Subject: AU-26-00002 Engle - Notice of Application

CDS is requesting comments on the following Accessory Dwelling Unit application: AU-26-00002 Engle.

A1.0

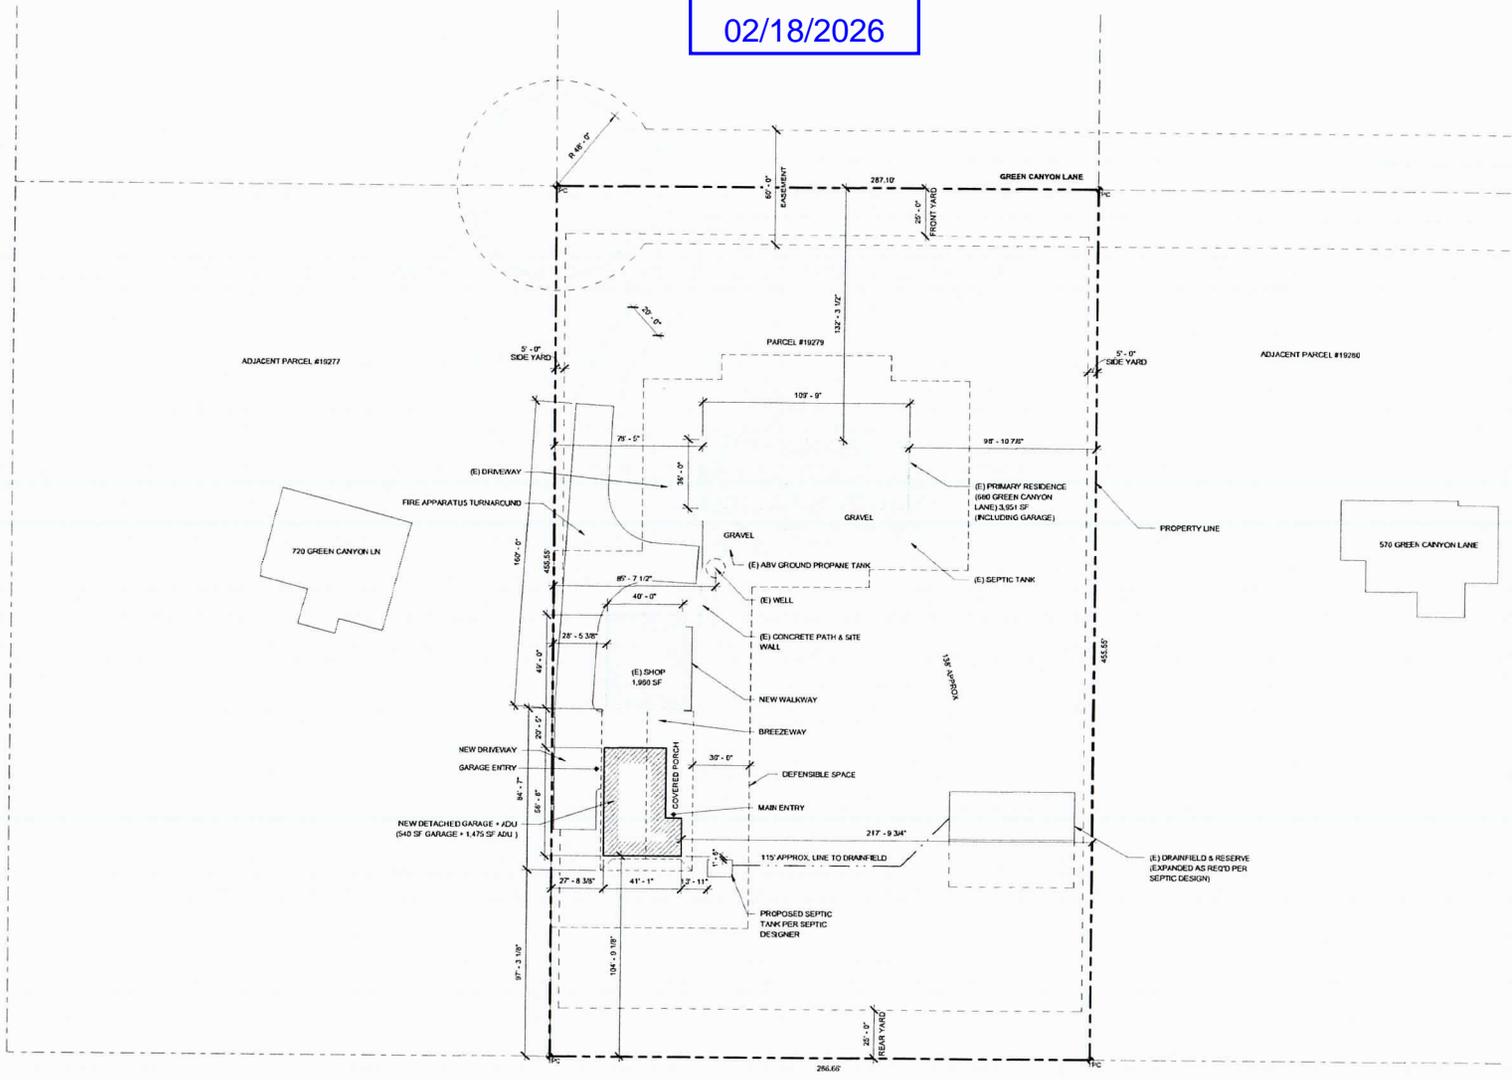
KITTCOM input is to ensure addressing meets current guidelines and is visible from both directions of travel on the access road.
